**Louise Boughton & Glenn Sharpe**

**The White House, 114 Ballymun Road, Glasnevin, Dublin 9.**

**Response to the applicant's responses to our Submissions;**

ALBERT COLLEGE PARK INTERVENTION SHAFT. PLAN
SCALE 1:400

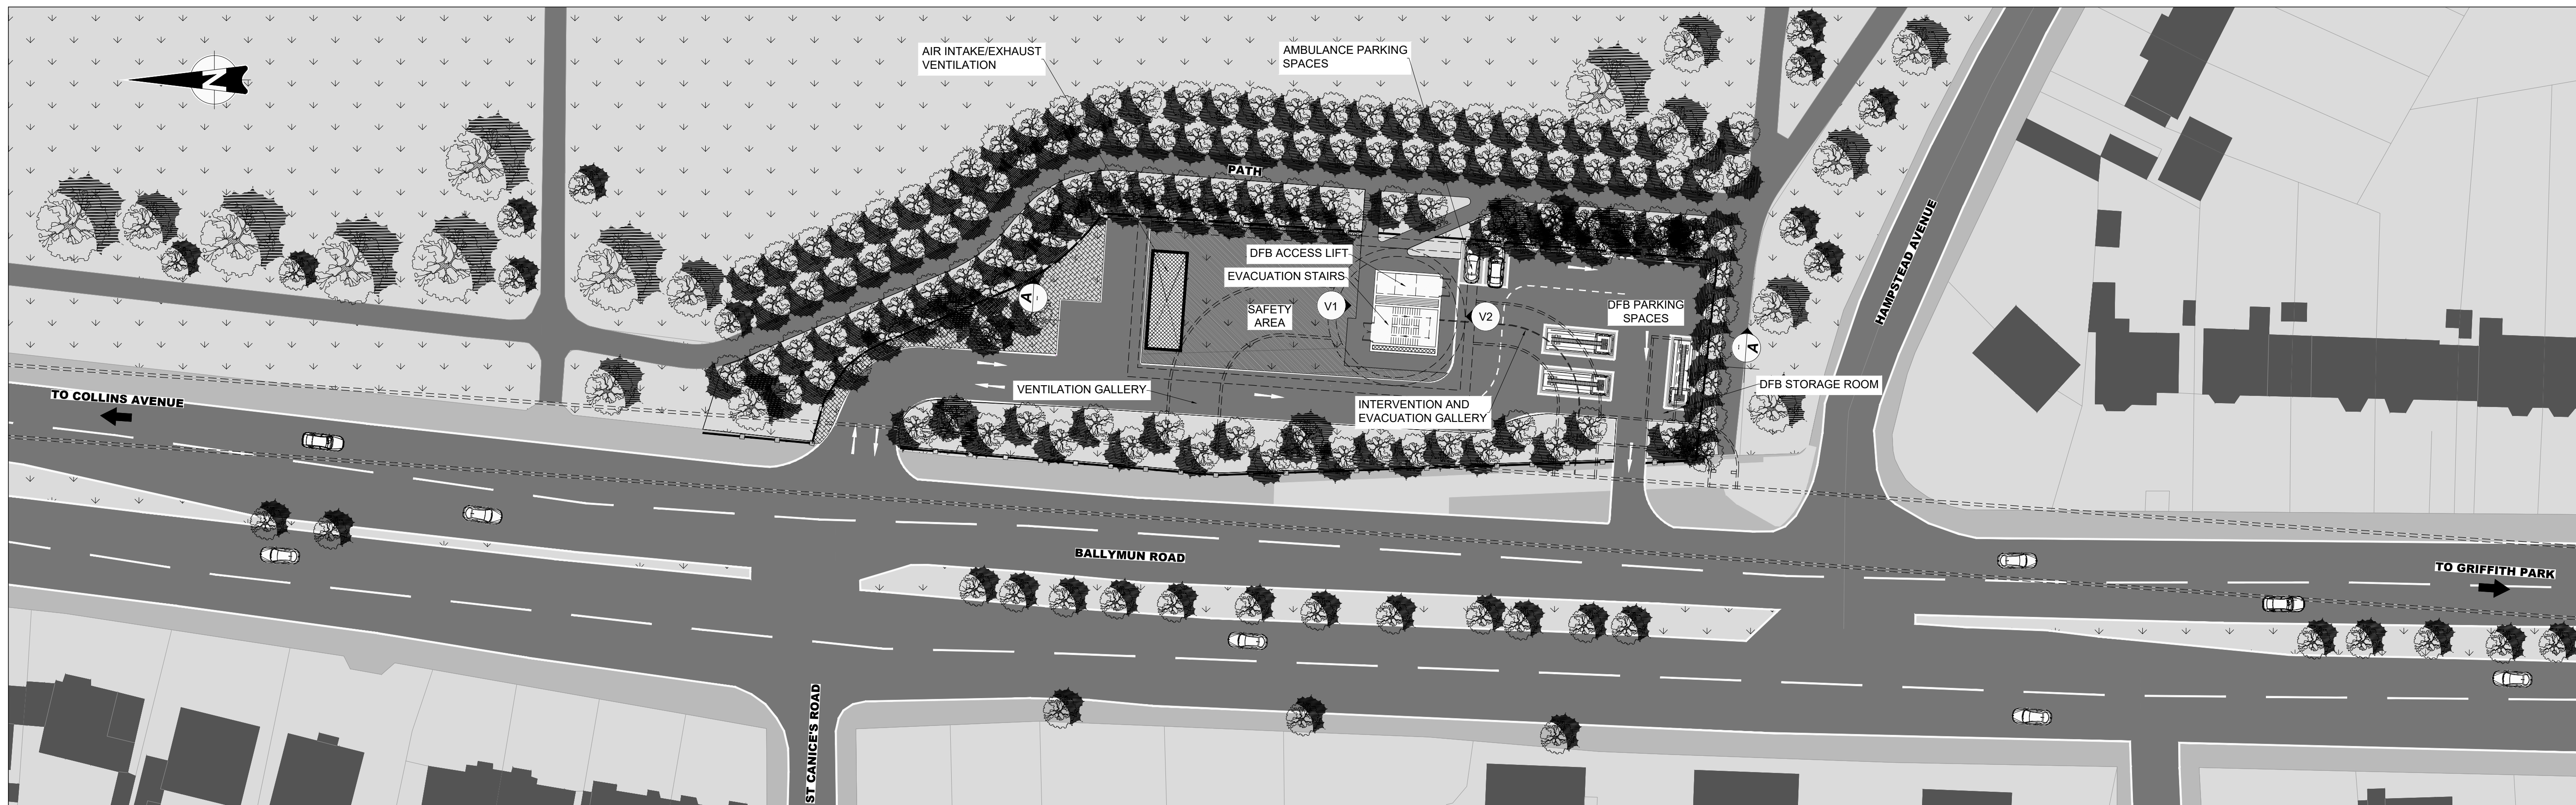
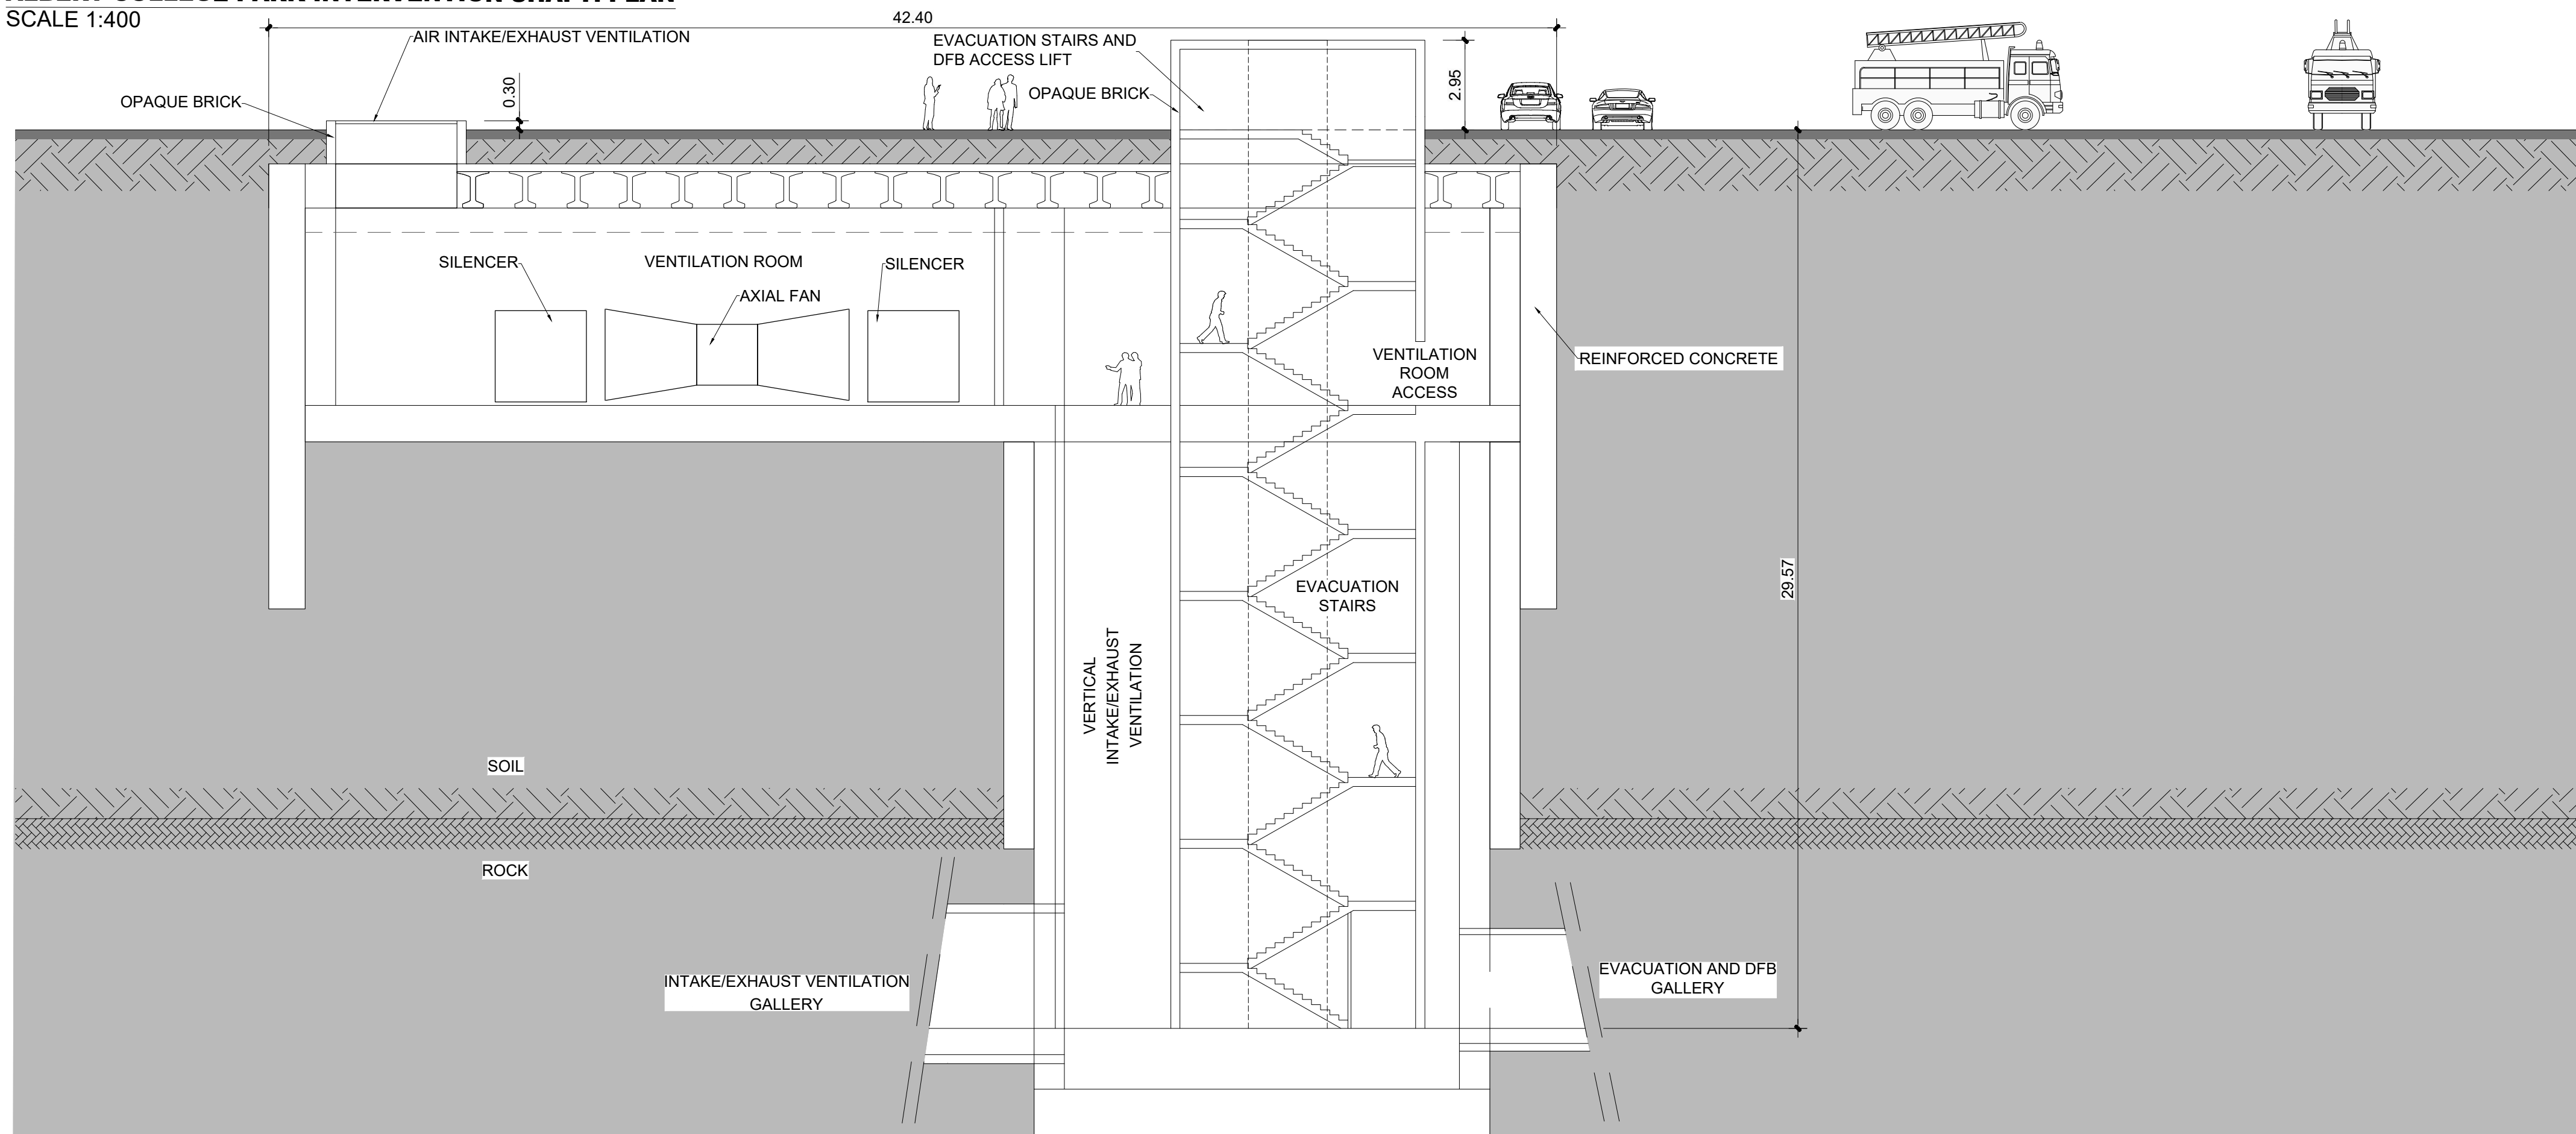
**Preliminary remarks – if the Intervention Shaft goes ahead in the proposed location being the SW corner of ACP our house will be the closest home to the shaft. We note that the noise measurement for construction stage is measured at 70dc and is in the moderate to significant category. The best noise barriers in the world will still mean noise on a daily basis for 6 days a week for up to 11 hours a day Monday to Friday. Our house has single pane glazing which had to be maintained per the planning permission we obtained when we restored our windows. We have grave concerns about the ability of single pane glazing to withstand the vibration associated with constructing the shaft. We already know from living in the property that single pane glazing does not protect against noise. We want the Inspector to note these two issues in particular as we outline are responses in relation to concern 5 and TII's response.**

The provision of a PCA is with respect not due cognisance. In our respectful submission consideration ought to have been given to locating a station in Albert College Park which avoids a need for an intervention shaft. As stated our house, a protected structure, will be the closest property to the shaft if it goes ahead in its proposed location. The windows in our house are single pane glazing and we are very concerned that the construction of the shaft has the potential to damage the house in particular the windows. In addition the noise and vibration of the shaft construction will have a very significant impact on the house and in particular the windows. The windows were the focus of a conservation and restoration project over the course of two and half years carried out by specialist metal experts and overseen by the conservation department of Dublin City Council. We cannot overstate the potential damage to the glazing that can be caused by the construction of the shaft in the south west corner of ACP. So the provision of a PCA does not alleviate our concerns. If the Inspector was to consider the construction of station in the midway section of ACP this would we believe afford protection to the house and the windows as the station's proposed location is slightly further away from the house and meters matter. The house is a protected structure for a reason – let's protect it.

We maintain our view that the intervention shaft has been poorly planned. TII's response misses the point entirely. We object to a shaft at this location. TII seem to think that because they decided to construct a shaft in the South West corner of the park and paid lip service to a consultation process about the shaft that they can now say that they have complied with their duty in the context of the intervention shaft. The park is not the appropriate location for

TII say that the intervention shaft has to be in the South West corner of Albert College Park or in a residential area south of Hampstead Avenue. We want the inspector to consider no shaft in this section of the route and a station

instead in the midway section of Albert College Park which obviates the need for a shaft given the distances between stations.

Thousands of people will be affected by the construction of the intervention shaft in the south west corner. The time taken to construct this very difficult and complex shaft is estimated at 63 months. We say that if the local community are to be denied the amenity of the park and exposed to noise, dust, vibration and generally intolerable conditions for that length of time that at the end of that period we are entitled to a station. If the station is located in the midway section of the park it is further away from Hampstead Avenue and indeed 114 Ballymun Road. It is a matter of metres but in the context of this development metres count.
